**West Yorkshire Police
Kirklees District**

To: Laura Yeadon Kirklees Council Planning Services	Ref: 2020/90682 Date: 24 th March 2020
--	--

Commercial Site Location: Croft Medical Centre, Cobcroft Road, Fartown, Huddersfield, HD2 2RU
Application Type: Discharge of condition 6 – Boundary treatments

Drawing:
Site Plan
Boundary Treatment

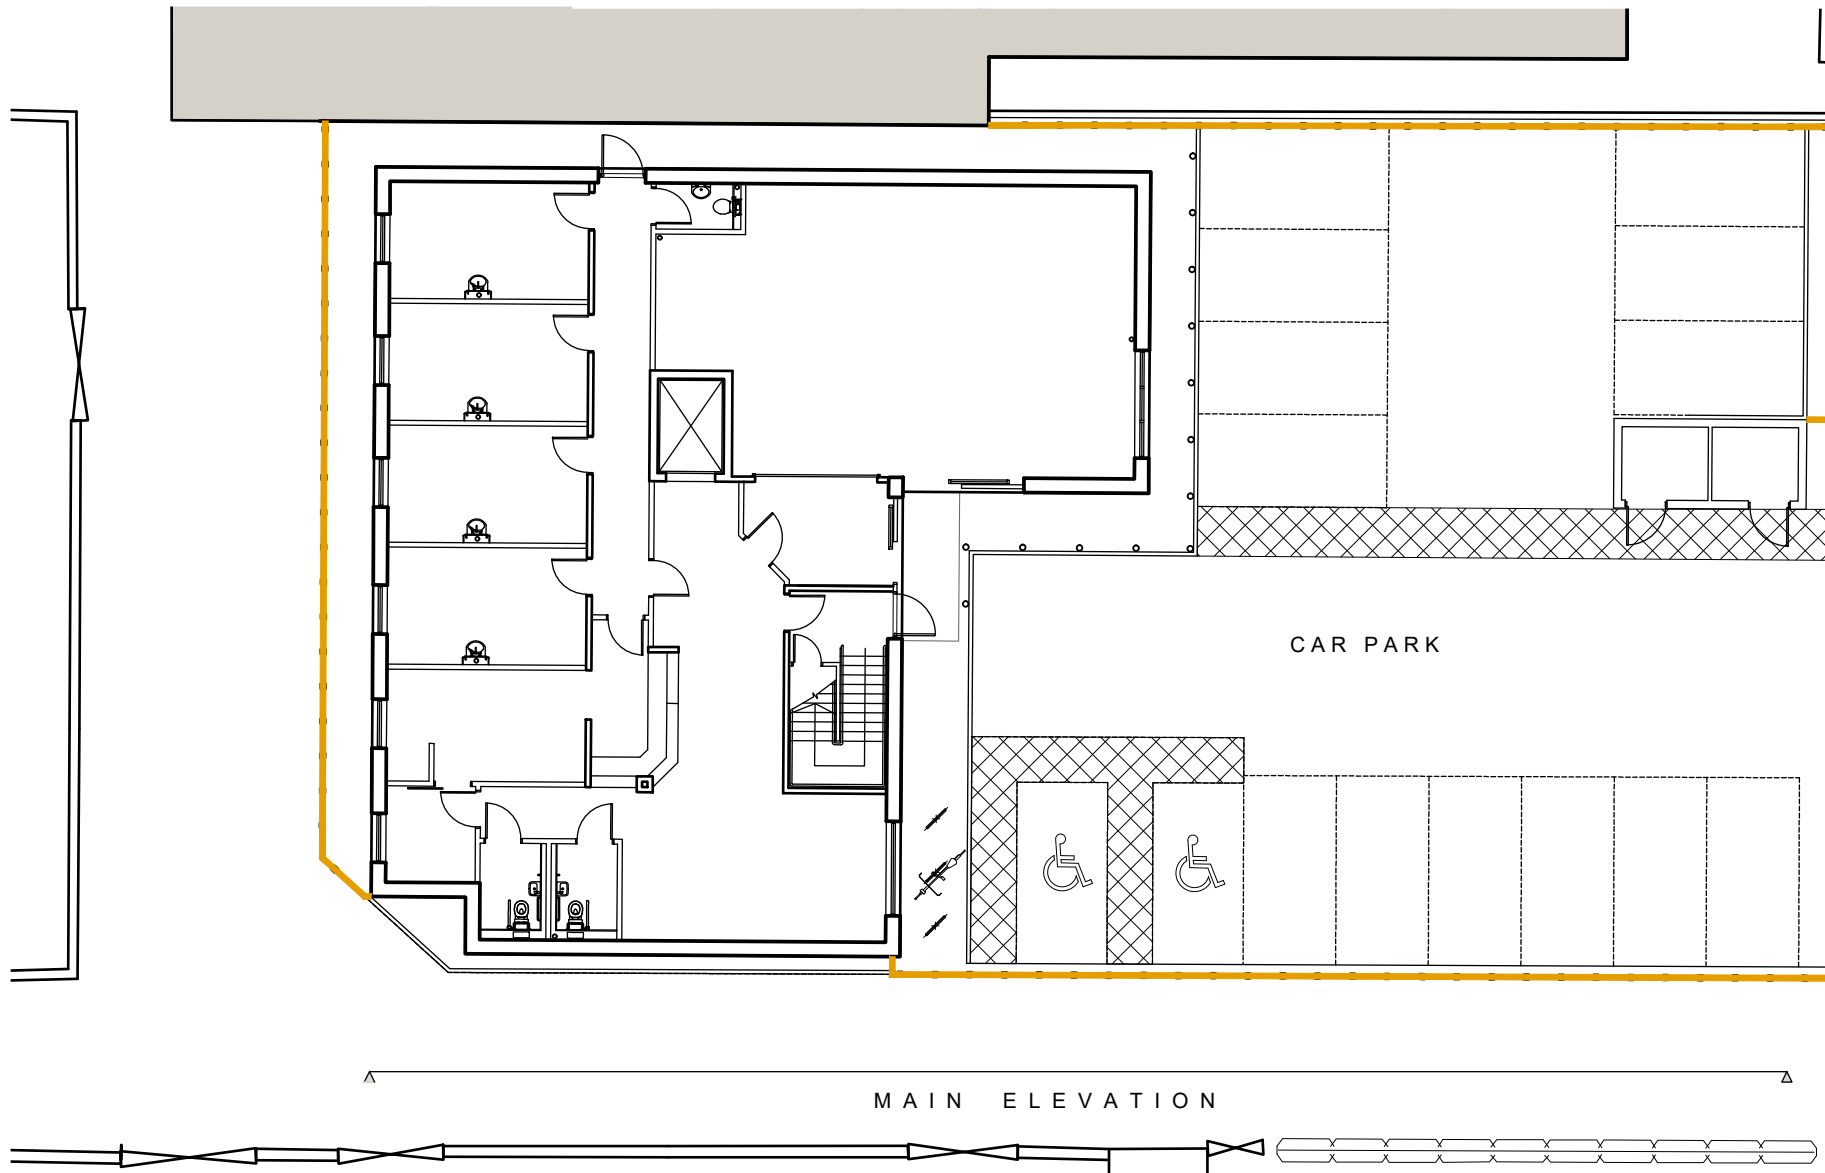
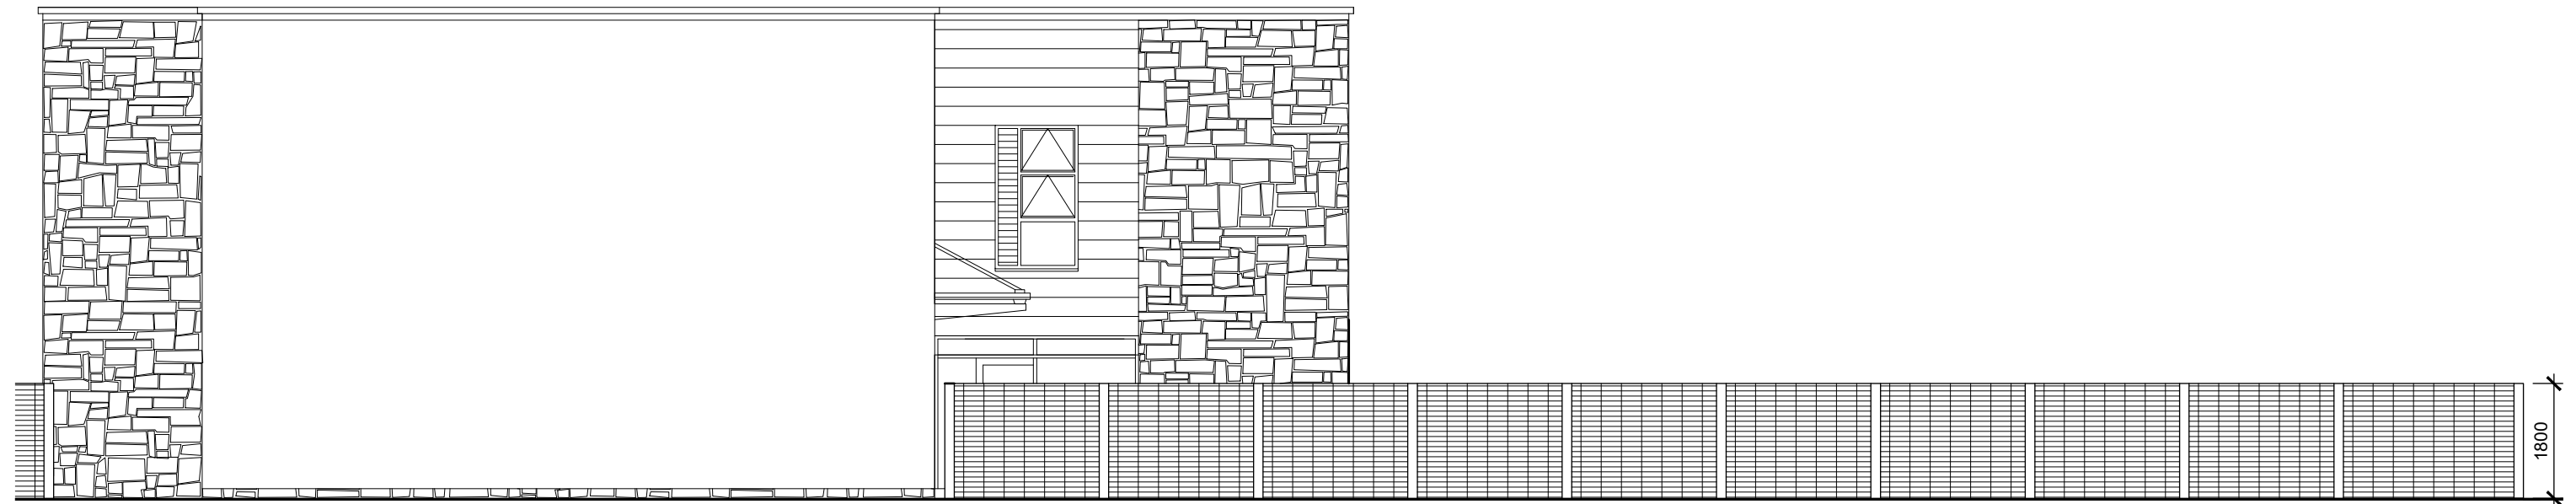
Gates

The design, height and construction of any gates within a perimeter fencing system should match that of the adjoining fence and not compromise the overall security of the boundary.

Access must be restricted to the perimeter defensible space from public land by installing a lockable gate of the same material and same height as the fencing. It is advised that the gate construction is such that no footholds or cross members are accessible from the outside of the gate, especially around the locking mechanism to prevent climbing.
